**SUBMISSIONS TO MP 08_0141
GEORGE EVANS ROAD, MUNDAMIA**

<i>Submission</i>	<i>Comment</i>
NSW DEPARTMENT OF PLANNING & INFRASTRUCTURE	
<p>1. <u>Flora and fauna issues</u></p> <ul style="list-style-type: none"> • The EA has not established that a suitable offset is proposed for the loss of native vegetation, removal of threatened species and habitat as a result of the project. • The bio-banking assessment methodology, or Property Vegetation Plan (PVP) calculator, should be used to determine the appropriate level of offsetting for the loss of habitat and impacts on threatened species. • The impact of the project on threatened species, and particularly groundwater dependent species, has not been satisfactorily addressed by the EA. You should demonstrate that water management will maintain suitable hydrologic conditions for ground water dependent threatened species, in particular the endangered Nowra Heath Myrtle, and for areas of Kunzea shrubland (an indicator of possible presence of the critically endangered Spring Tiny Greenhood orchid), refer also to comments below in relation to water management issues. • The National Recovery Plan for Nowra Heath Myrtle <i>Triplarina nowraensis

REF. NO. **25489-08**
SHEET **1** OF 1 SHEETS
REVISION **02**

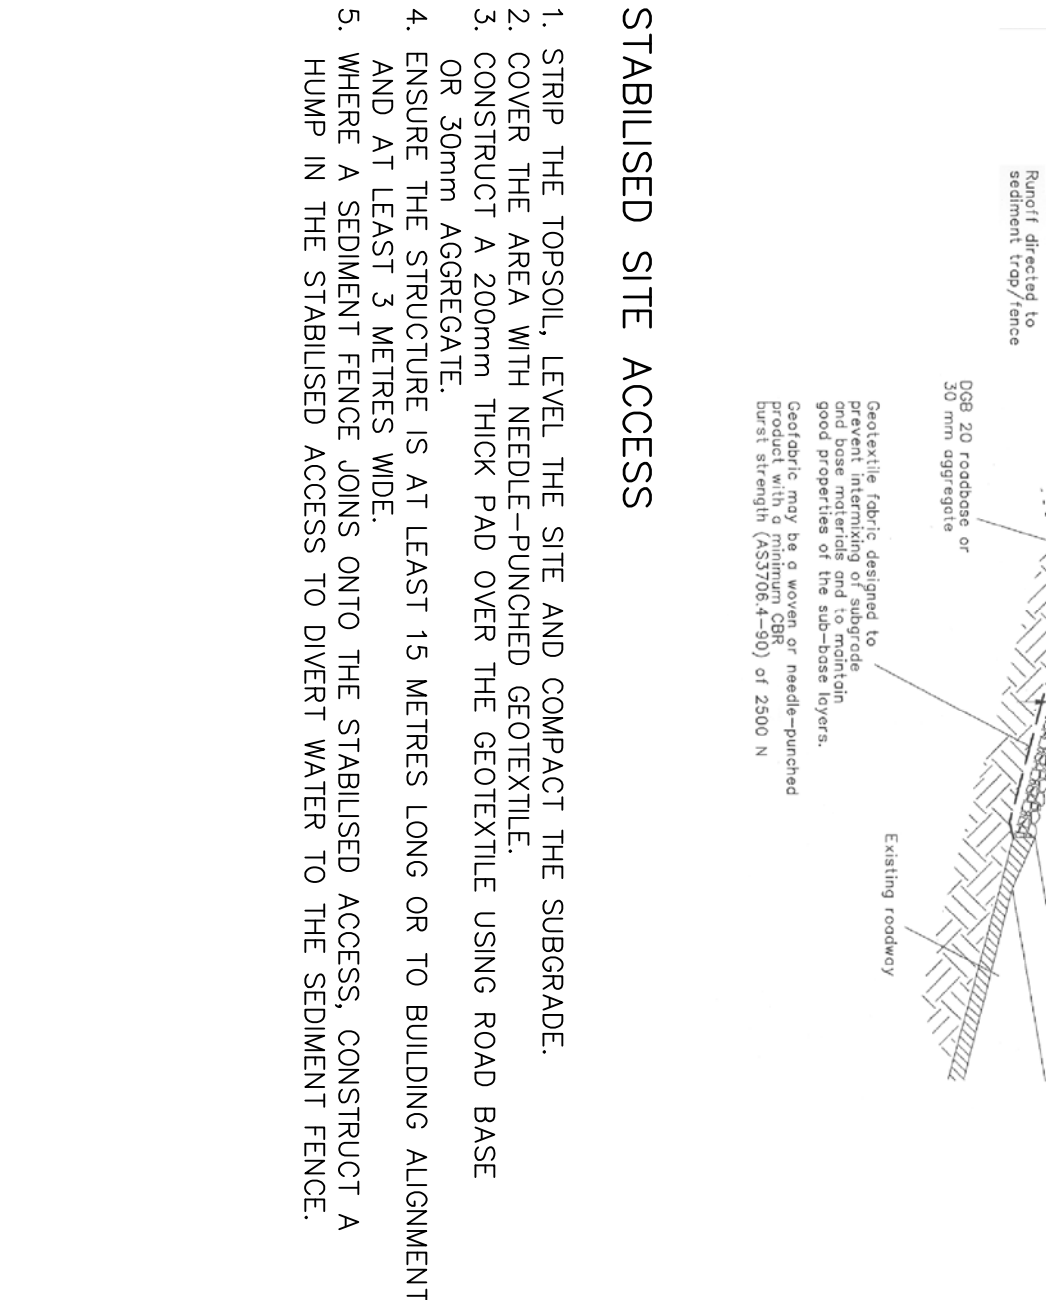
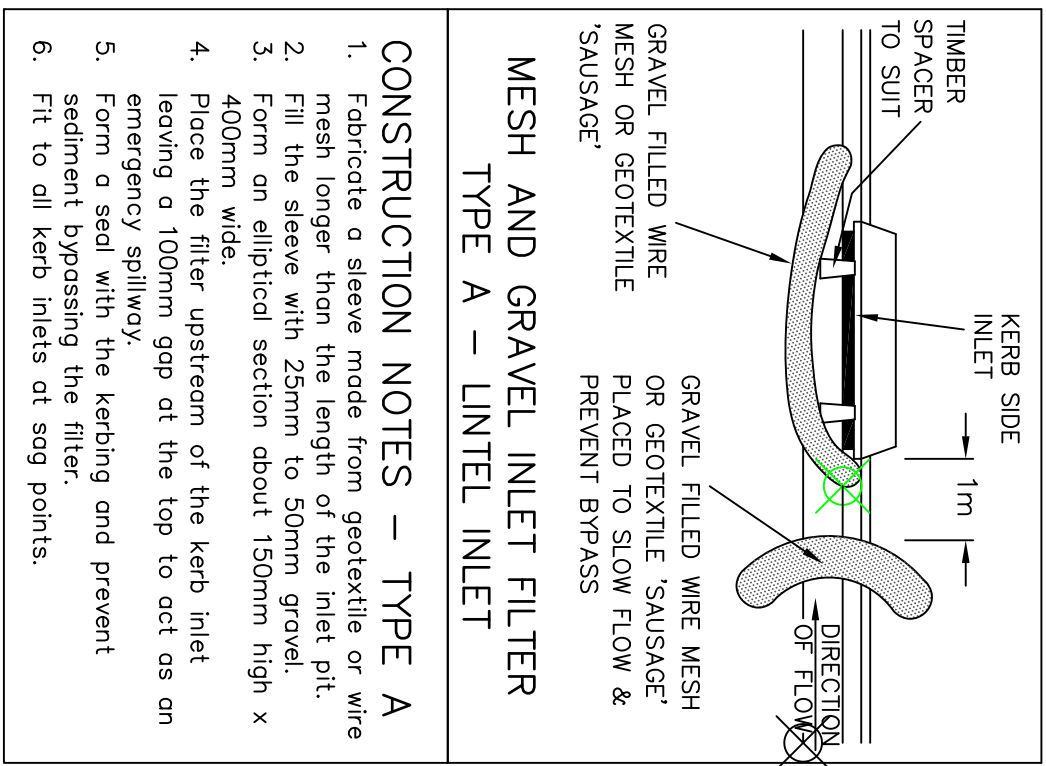
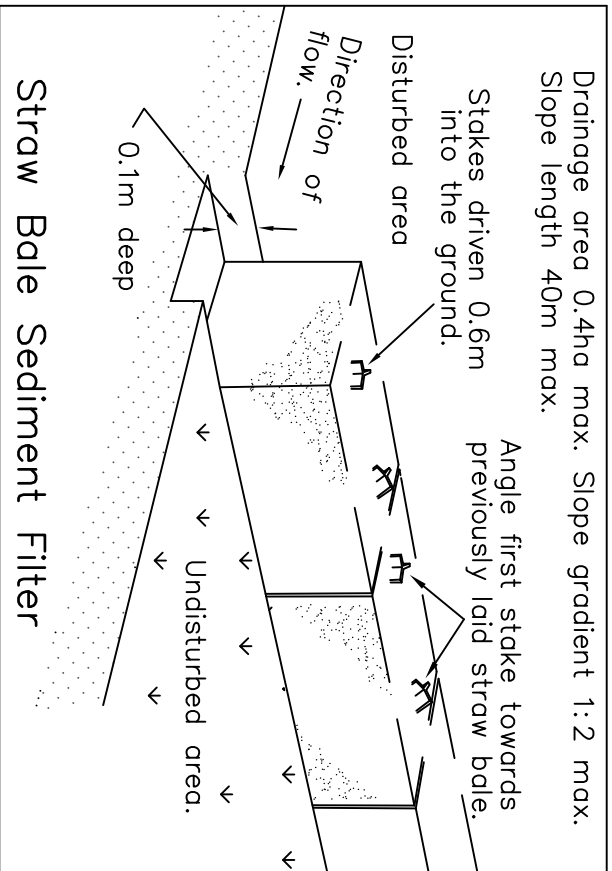
Submission	Comment
<p>Sewerage Services:</p> <p>Plan No. 25489-07 sheets 1 to 3 by Allen Price & Associates need clarification. Sheet 1 of 3 does not correlate with sheets 2 and 3. In addition the electronic title provided for these documents does NOT match the drawing number on each respective plan.</p> <p>It is noted that the EA report by Cowman Stoddart P/L references Section 64 sewerage services rates (refer to page 84) which are 2011/12 year and not the current 2012/13 year. The Section 64 sewerage services rate for 2012/13 is \$8,339/lot created.</p>	
DEPARTMENT OF DEFENCE	
<p>The proposed subdivision is located in an area mapped by Defence as "Birdstrike Group B 8km Buffer Area" as indicated in the attached bird strike map for HMAS Albatross. In this buffer area the use of artificial water bodies needs to be controlled as they have the potential to attract wildlife which contributes to the risk of birdstrike. Defence understands that the proposed subdivision contains artificial water bodies for stormwater management. Defence is concerned that the proposed artificial water bodies will potentially increase the risk of bird strike for aircraft operating from HMAS Albatross. Defence requests that the Department of Planning and Infrastructure provide appropriate development conditions to ensure that the design of the artificial water bodies minimise habitat opportunities for birds and bats (eg by careful selection of landscaping, water body edge treatments etc).</p> <p>Defence notes that the subject site is constrained by building height controls that protect airspace near HMAS Albatross. The Defence (Areas Control) Regulations (DACR) restriction over the proposed site ranges from "structures higher than 45m require approval" and "structures higher than 90m require approval". Although Defence recognises that these heights are unlikely to be reached by residential buildings, any structure (including buildings, light poles, cranes, mobile telephone towers or vegetation) that exceeds this level will need to be referred to Defence for comment.</p>	<p>Comments are noted. Further detailed design of detention ponds can incorporate measures to ensure that these artificial water bodies minimise habitat opportunities through landscaping and the treatment of edges.</p> <p>Noted and does not affect this proposal. Future development within the Mundamia URA unlikely to be of a height to encroach into the area of concern (ie. 45 m or higher).</p>
